# Consultee Comments for Planning Application 23/01561/FUL

Application Number: 23/01561/FUL

Proposal: Erection of 1.5 storey self build eco friendly dwelling including garage, access, and residential curtilage.

On Behalf Of: Tree & Landscape Officer

Street Scene & Prop Site Plan

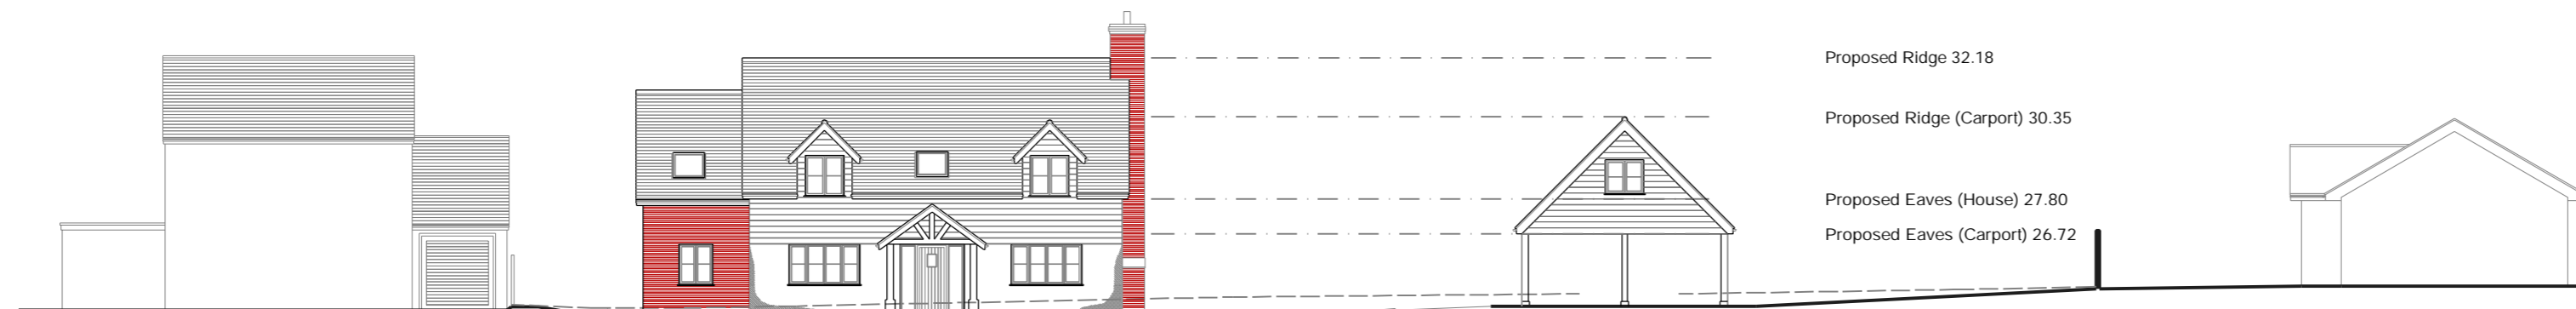
The boundary with Michealstowe drive is demarcated by a low, sparsely populated, scrubby hedgerow comprising primarily of Hawthorn and Elm regrowth that has arisen from the roots of old trees that have died as a result of Dutch Elm Disease. There are 2 Sycamore and a Hawthorn on the boundary that make a pleasant contribution to the appearance of the area although their shape, form and amenity value is such that they do not merit protection by means of a tree preservation order.

It appears that access to the site can be gained with the need for the extensive removal of boundary vegetation.

The trees and hedgerow on the boundary with Michealstowe Drive should be retained for the softening impact that they have on the appearance of the public realm or if they needed to be removed to facilitate the development of the land then provision should be made for replacement planting.

Should planning permission be likely to be granted then details of soft landscaping should be secured by way of a planning condition and include tree planting to soften, screen and enhance the appearance of the completed development.
